**Mt Pleasant Optimisation Project – SSD 10418 – Muswellbrook Shire Council
Comment**

I refer to the Environmental Impact Statement, prepared by Resource Strategies P/L for Mach Energy P/L (“the Proponent”), for the Mt Pleasant Optimisation Project – SSD 10418. Council appreciates the opportunity for comment.

Figure 1 2D Slope stability model locations.

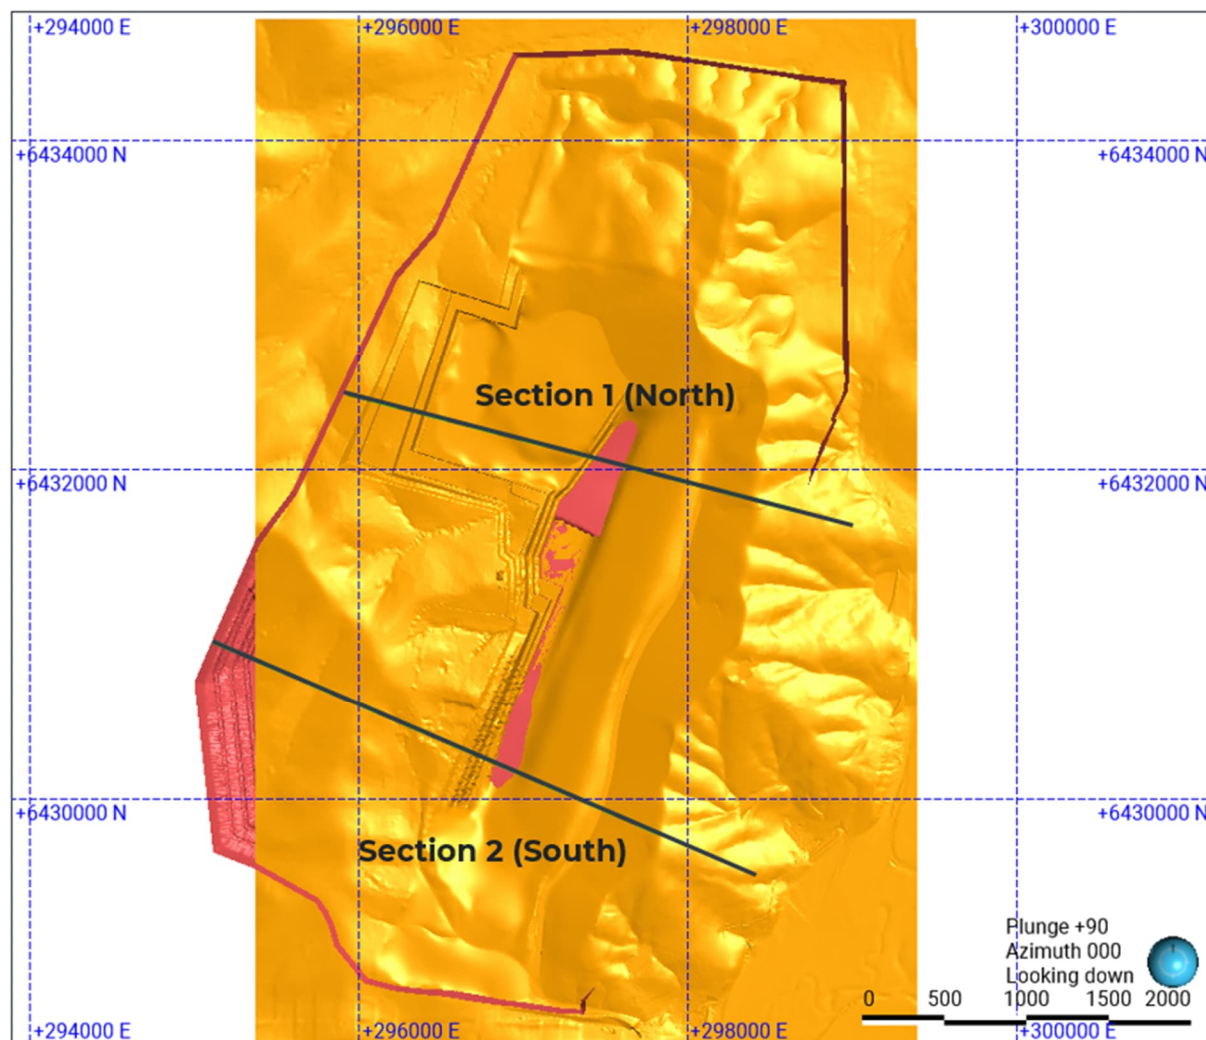
31.0 The slopes to the void, despite the improved landform shapes, are still very steep, in some places as much as 37 %. This creates a landform that will be difficult to maintain/traverse.

MACHEnergy MOUNT PLEASANT OPTIMISATION PROJECT Conceptual Final Landform

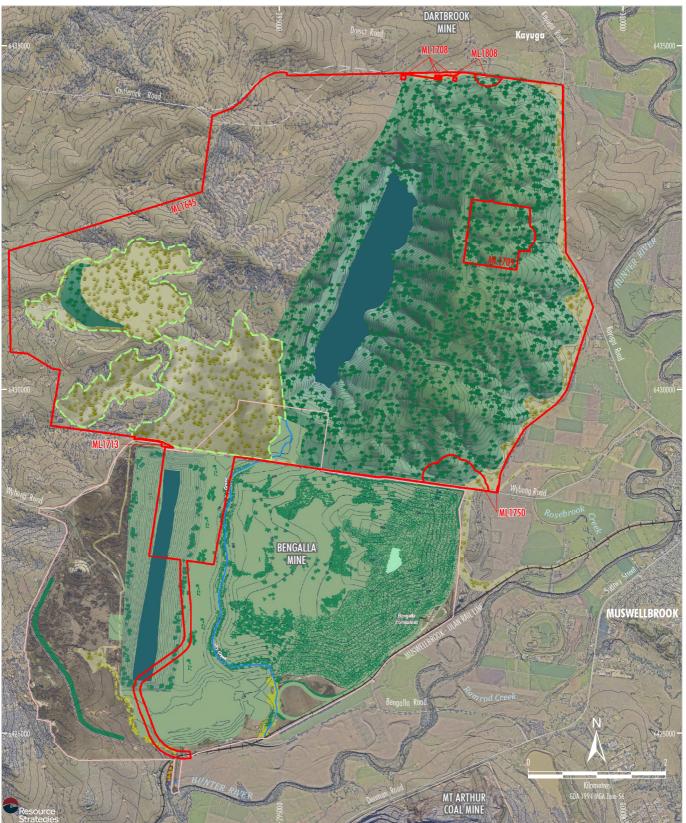
29.0 Despite changing from three voids to one, the impact on the landscape is significant due to the size of the proposed single void.

30.0 The proposed void will be approx. 3km long, 600-700m wide and 90m deep. This appears to be slightly shorter than the 3 voids from the 1999 approval combined, but considerably deeper. It appears to be the same length as the 3 voids approved by MOD 3 and it is not possible to compare the depth.

32.0 Voids are not a naturally occurring element in the landscape, so planning to retain a void is planning to create an irreversible and permanent negative change to the environment. At the same time significant visual impacts, including disruption to natural landscapes will result from the proposed emplacement.

33.0 Council requests that the Proponent amends the proposal:

- to further reduce the extent and depth of the void;
- to reduce the steepness of void slopes both above and below any final water line. For example, the final void slopes should maintain the same angle of the

rehabilitated void wall to the pit floor or where it meets the slope from the void slope from the opposite side'; and

- reduce the height of the emplacements.
